The following comments were addressed:
As-Built Construction Drawings

Drainage, Grading and Erosion Control Plan

Roadway Plan

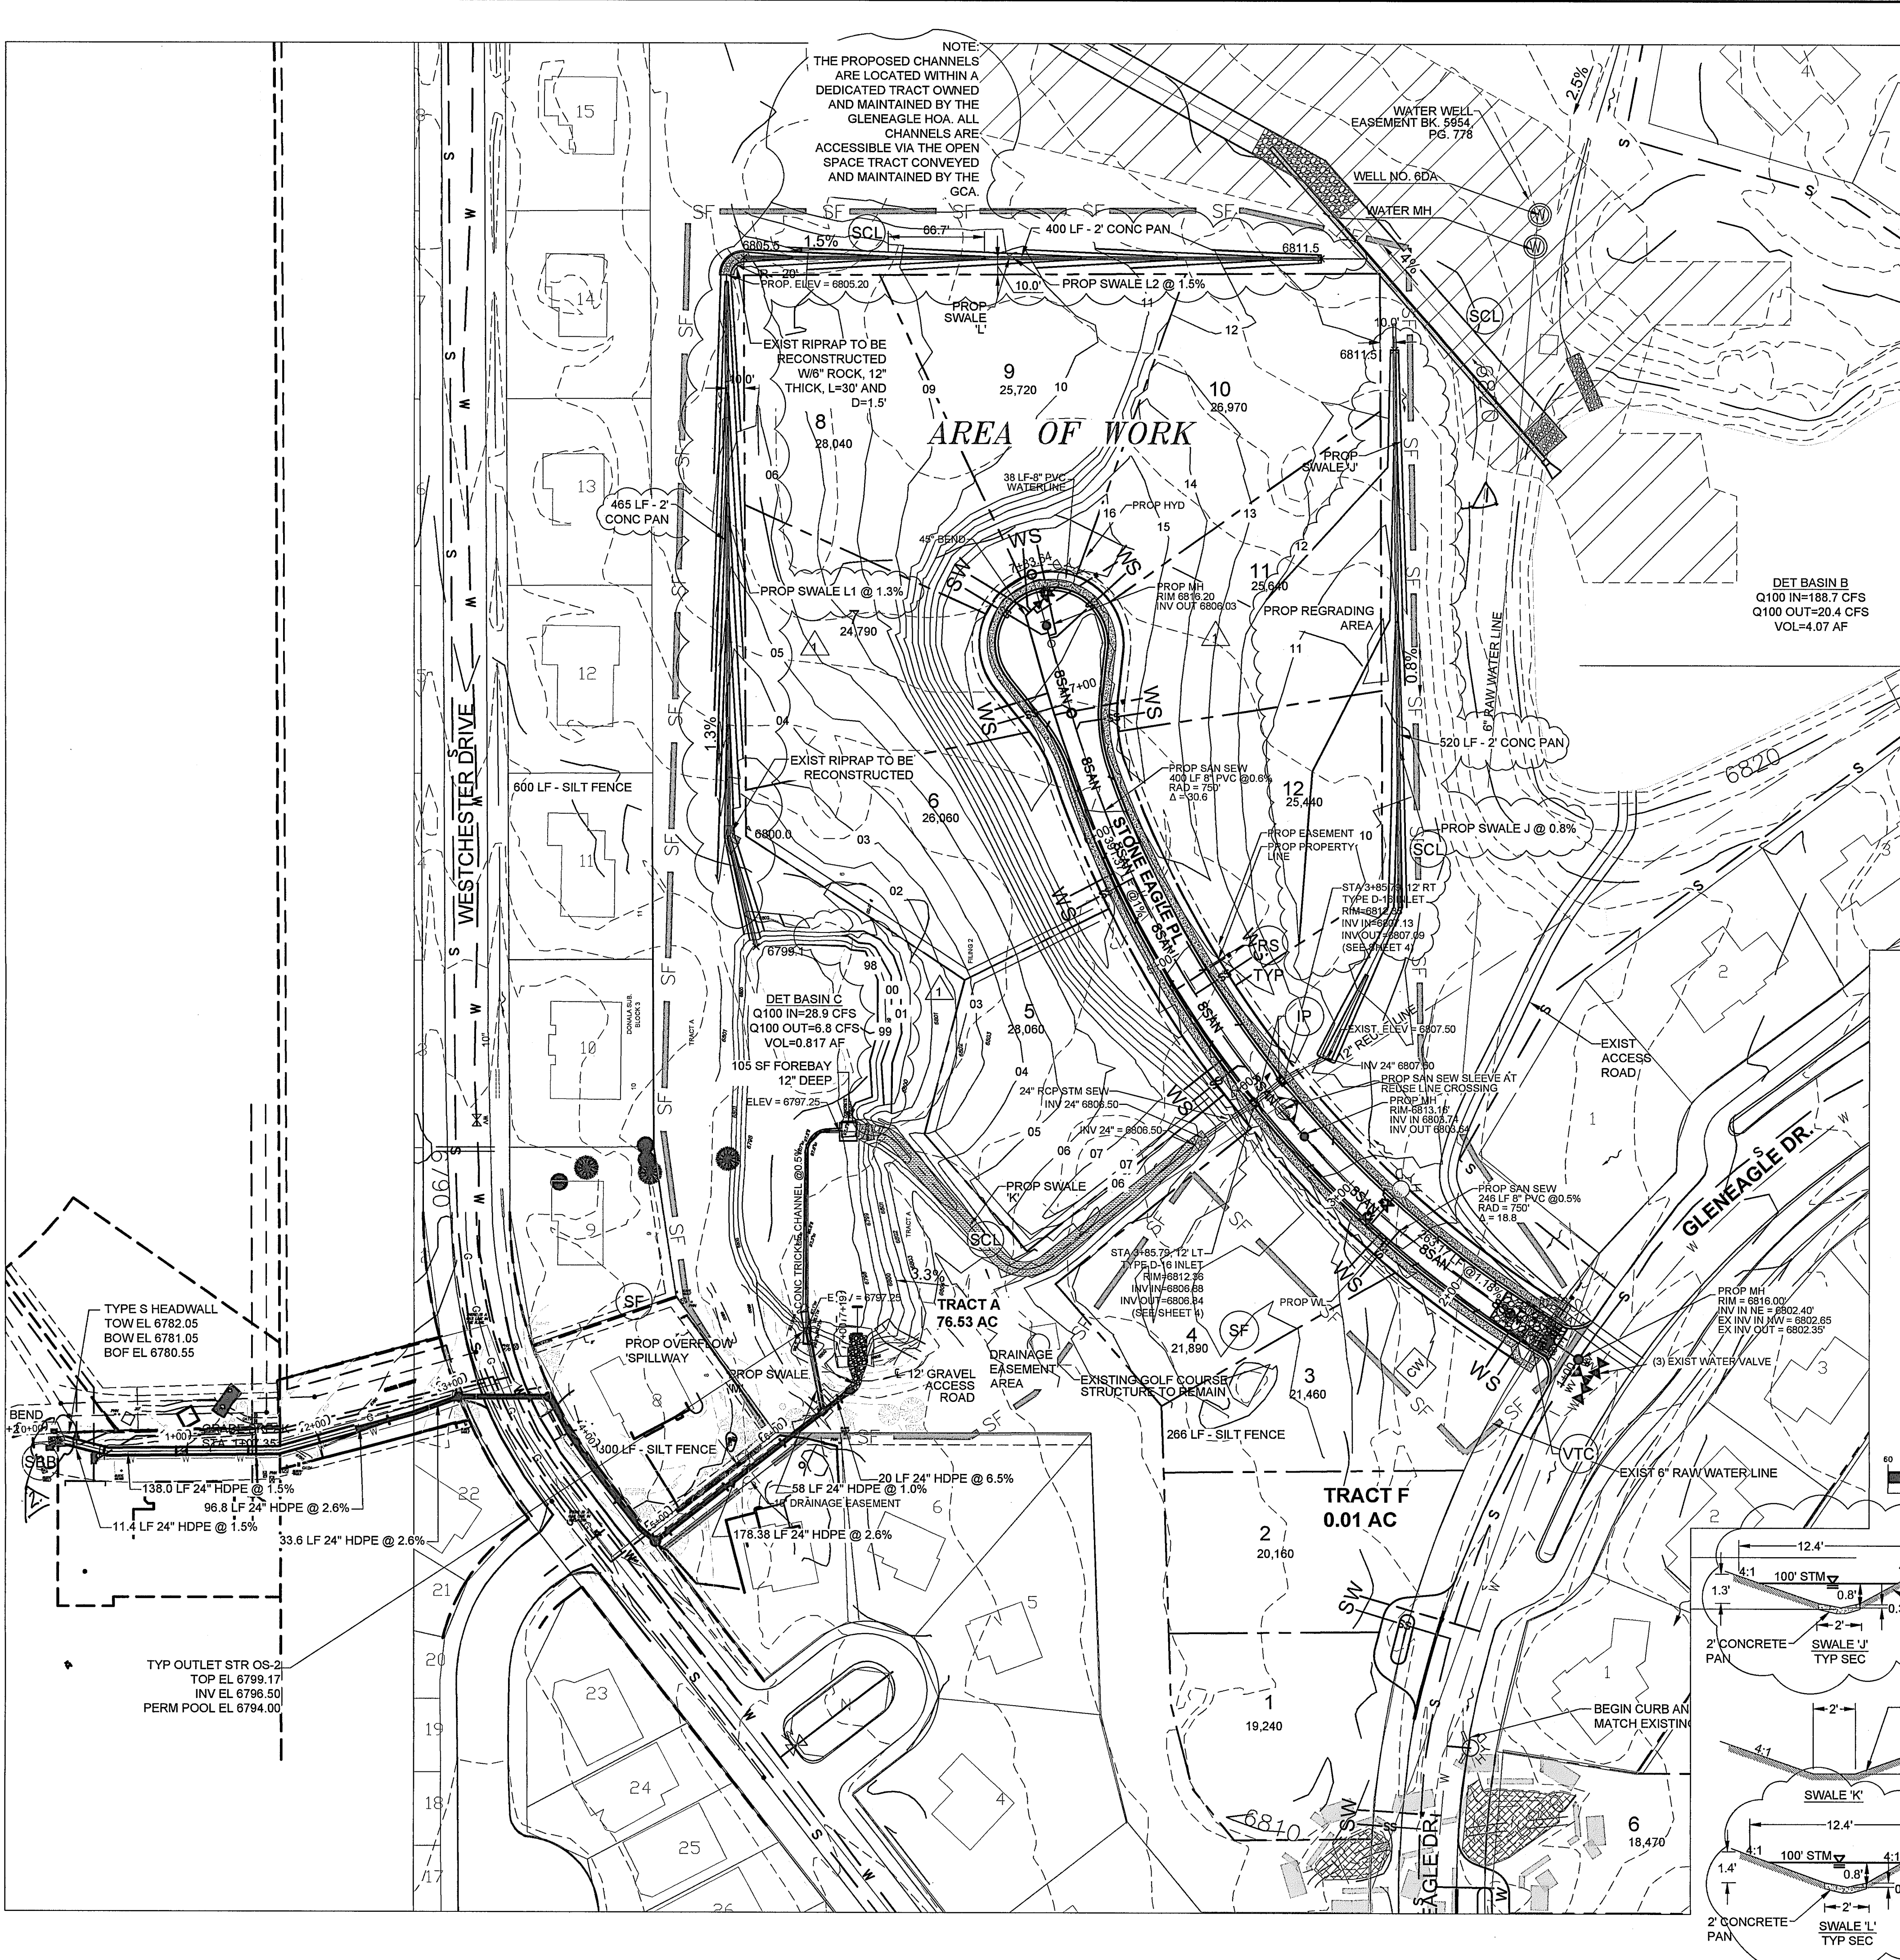
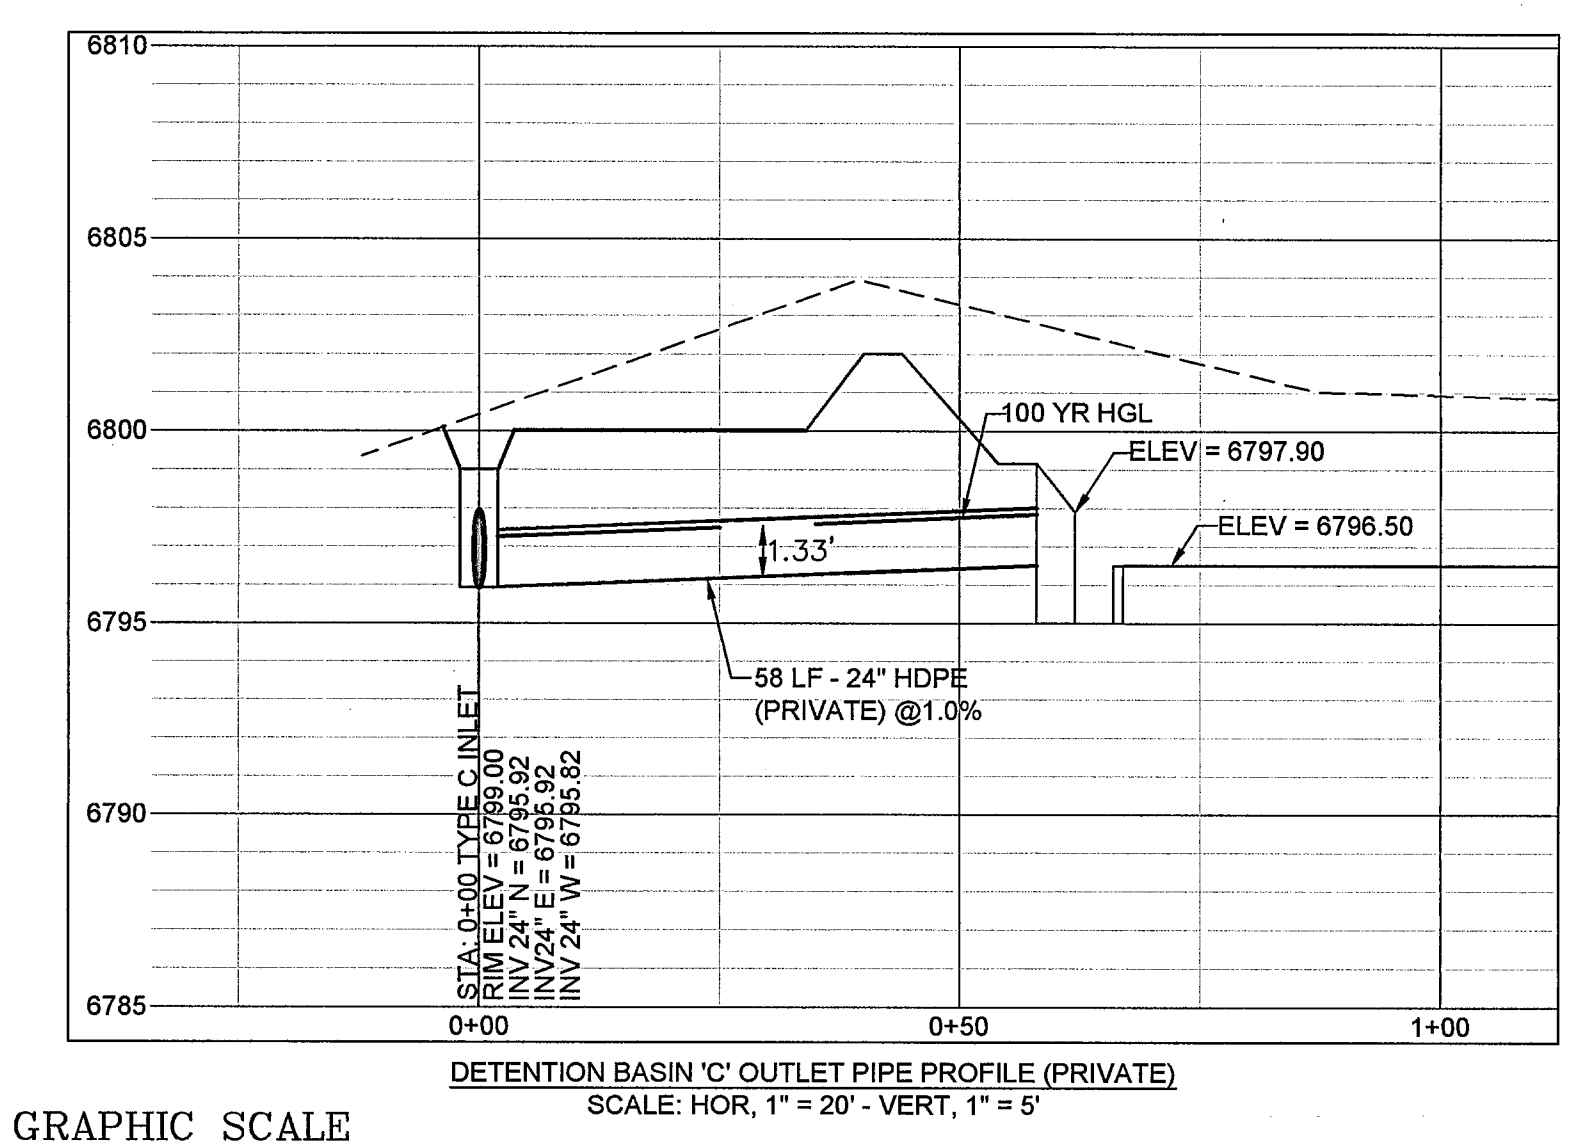
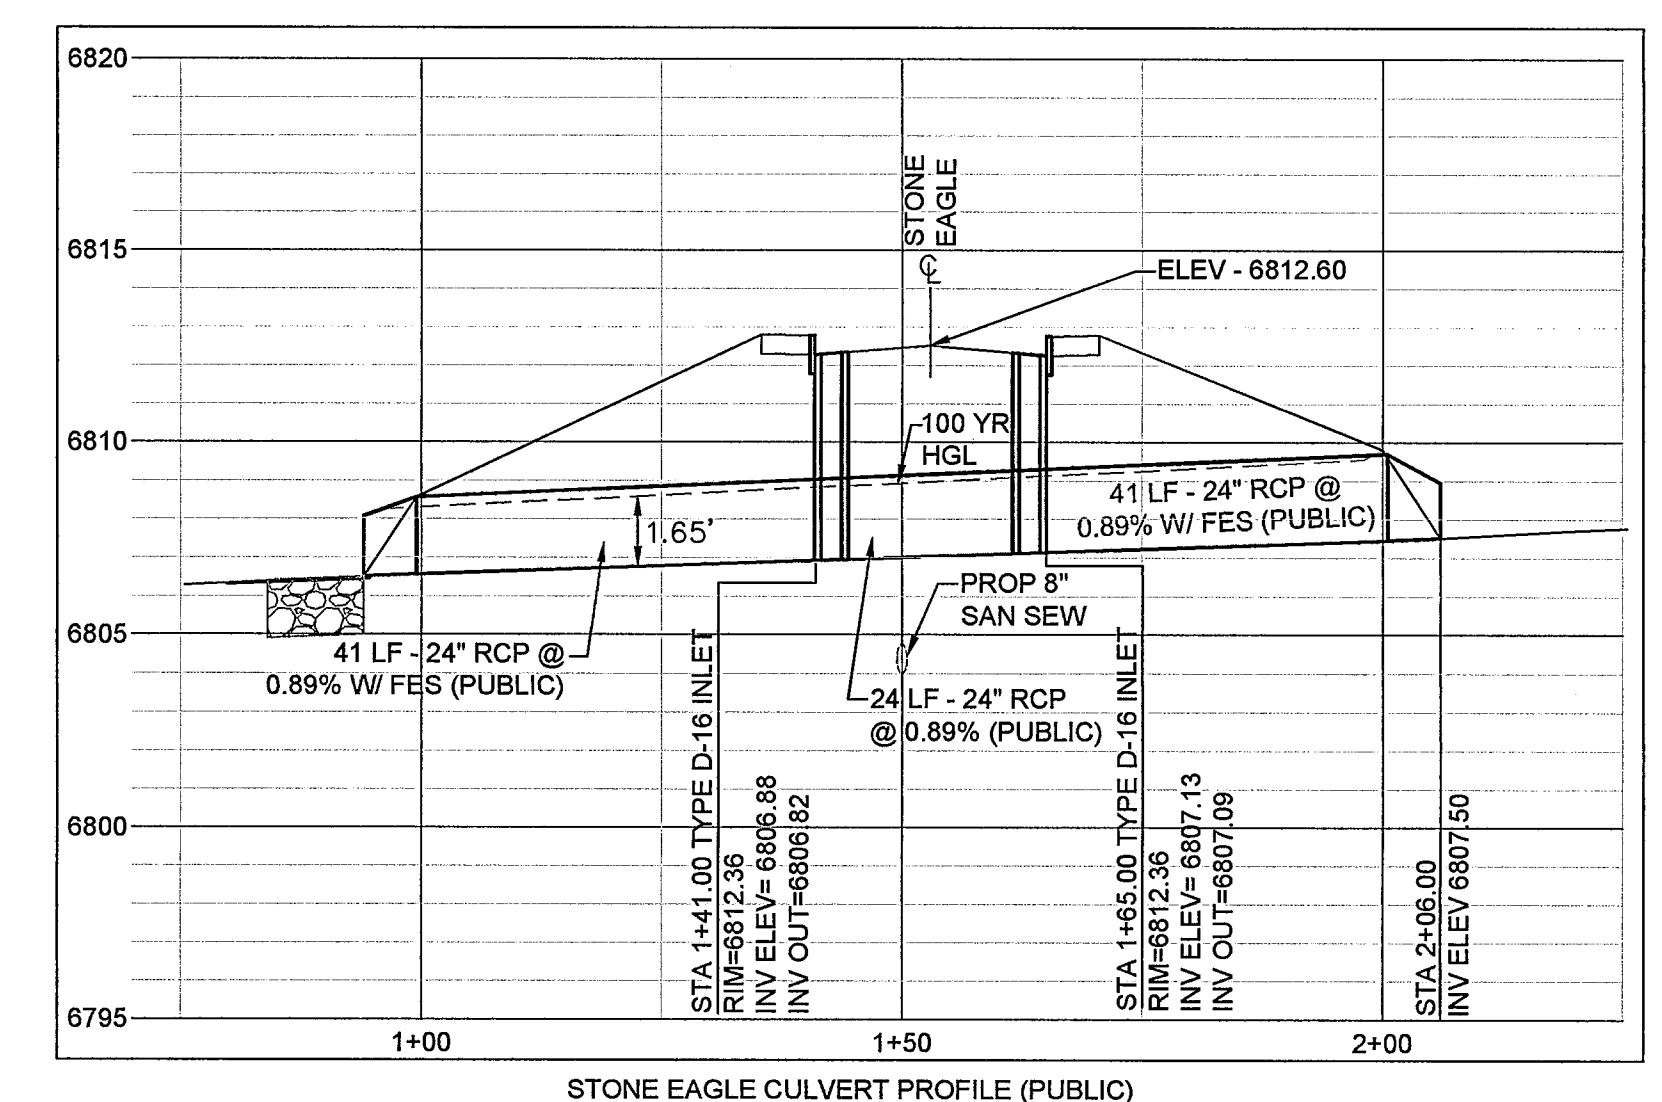
Sheet C2 – Emergency Spillway width revised to 26'
